KITTITAS COUNTY DEPARTMENT OF PUBLIC WORKS

MEMORANDUM

DATE: March 6, 2019

SUBJECT: Suncadia Phase 2 Division 5 (River Ridge II)

JOB NO.:	998-773-018
DWG. NAME:	PP-05
DESIGNED BY:	JH
DRAWN BY:	LGB
CHECKED BY:	
DATE:	01/21/2019
PRINT DATE:	
SHEET

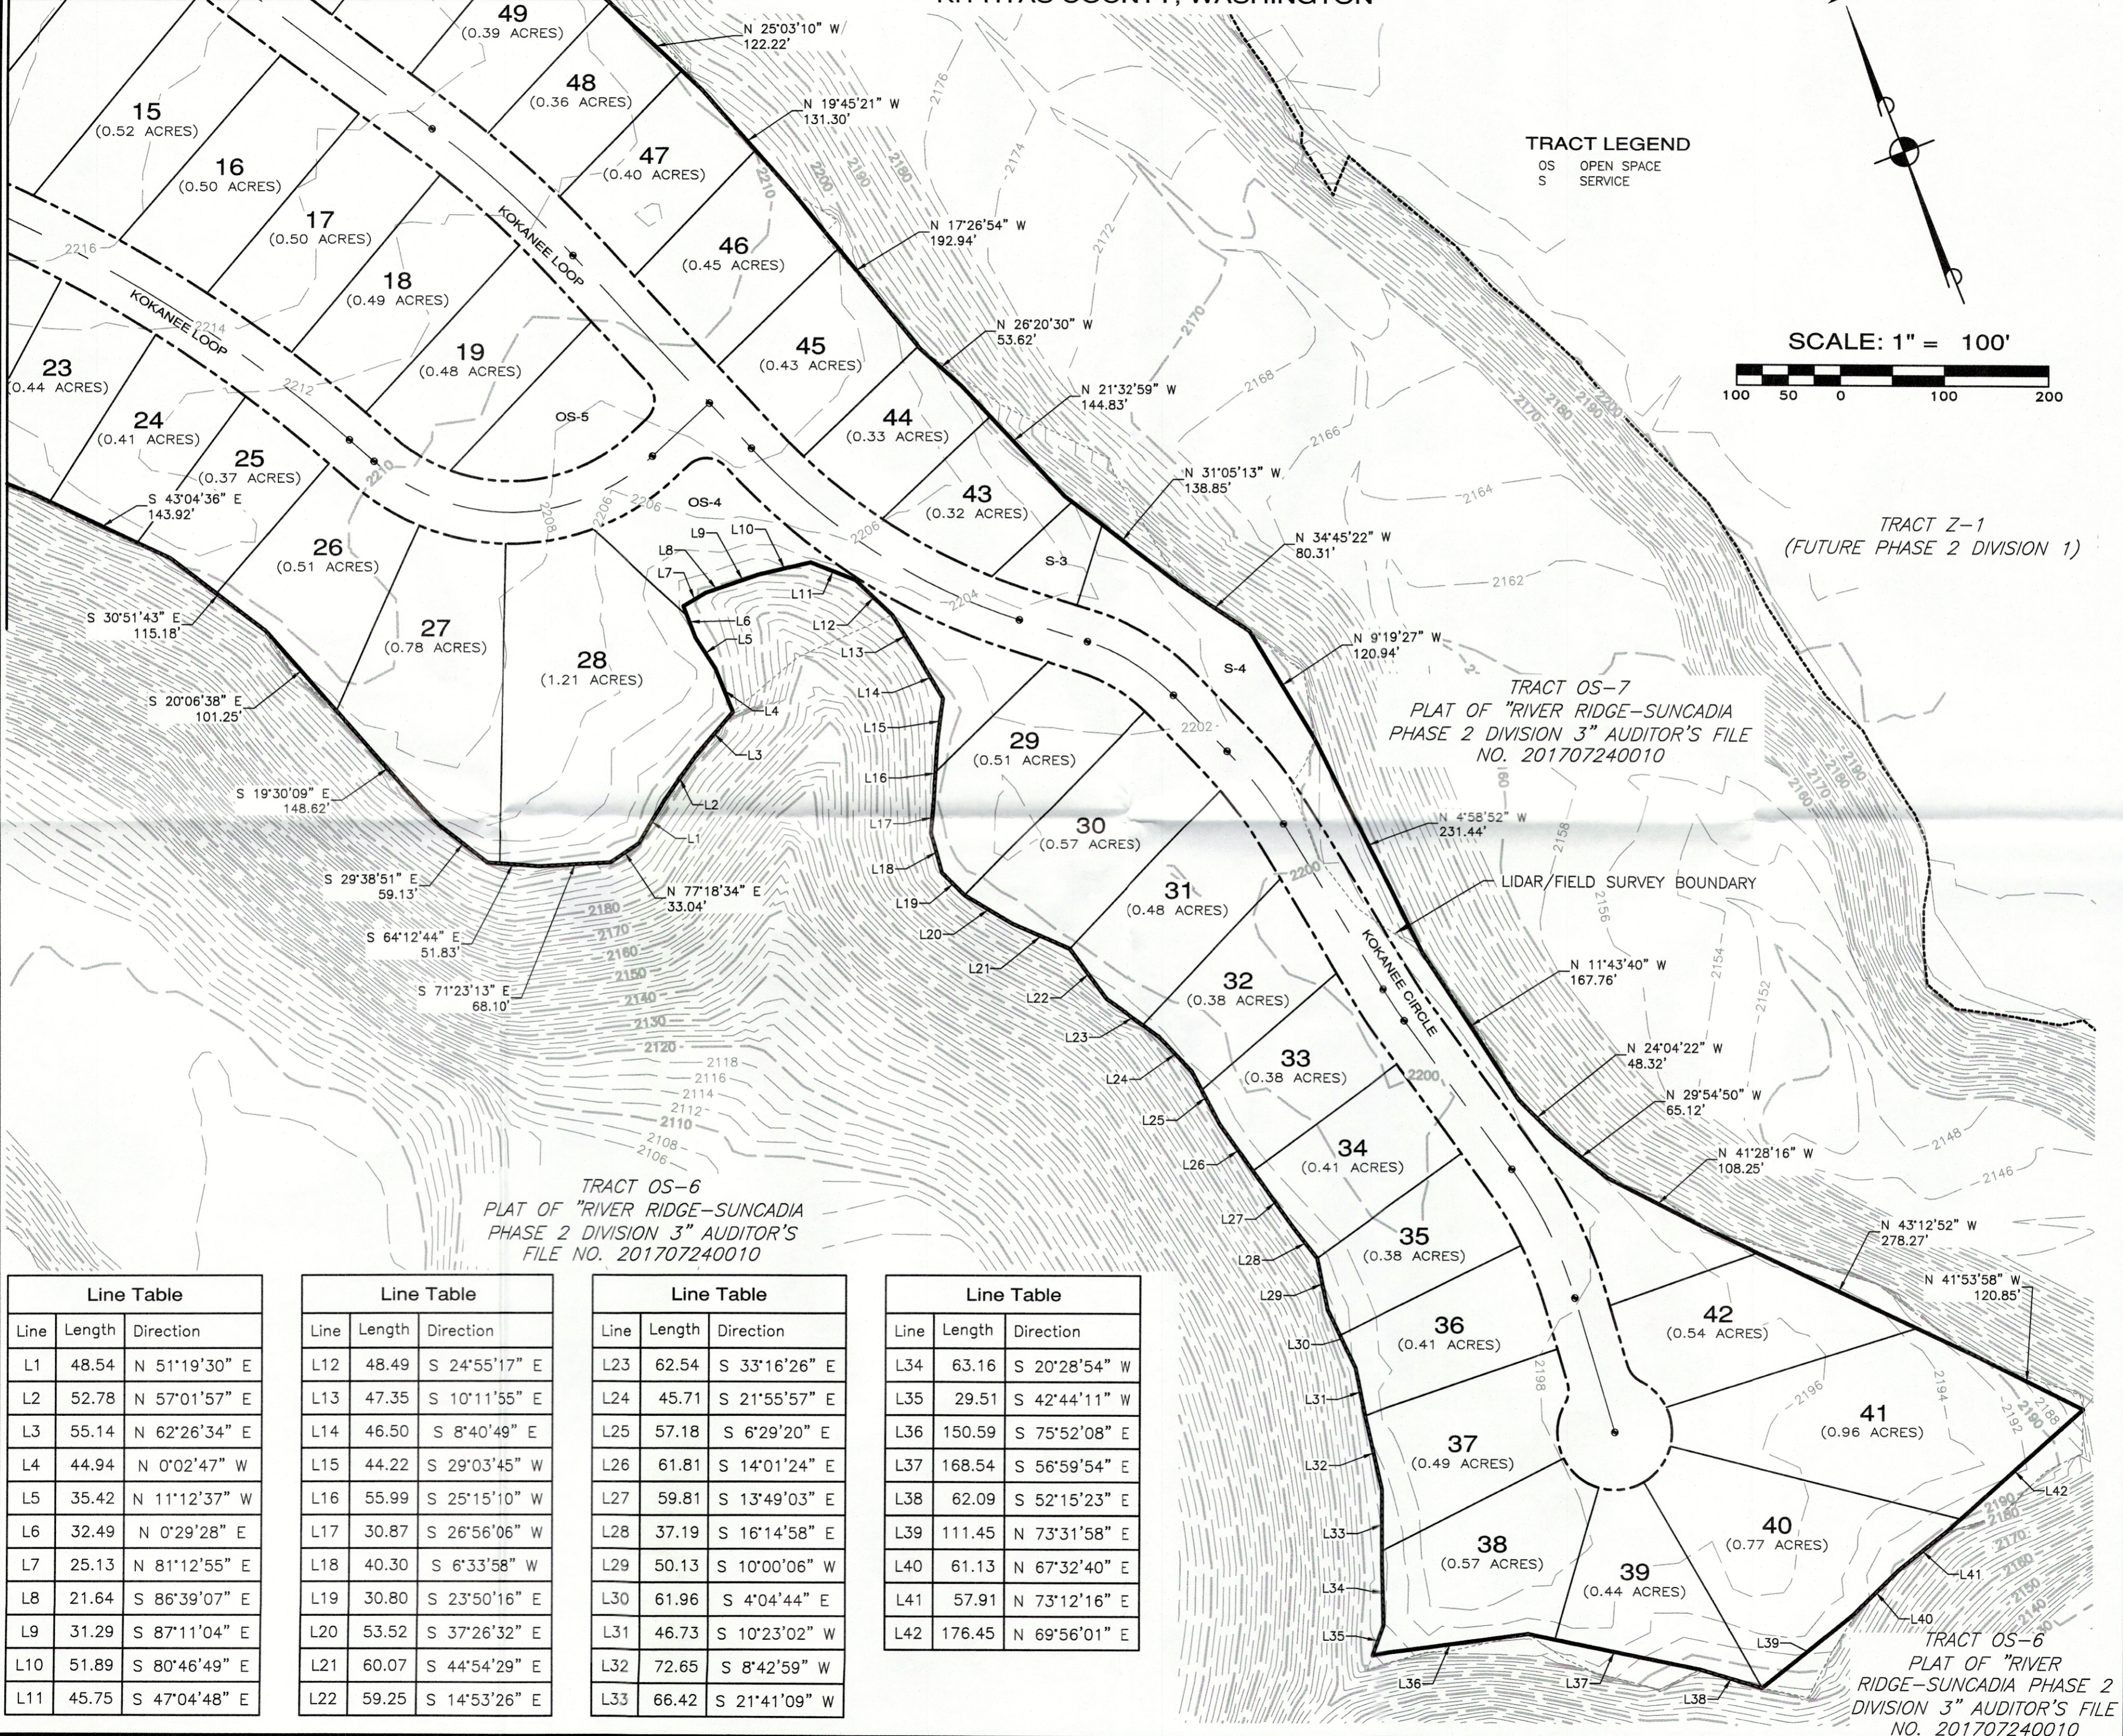
1. Sheets PP-1 through PP-5 shall be stamped by a licensed land surveyor. Please see KCC:16.24.010 for survey requirements.
2. Kokanee Loop and Kokanee Circle should show the 60' width and identify if the intent is a dedicated right of way or an easement.
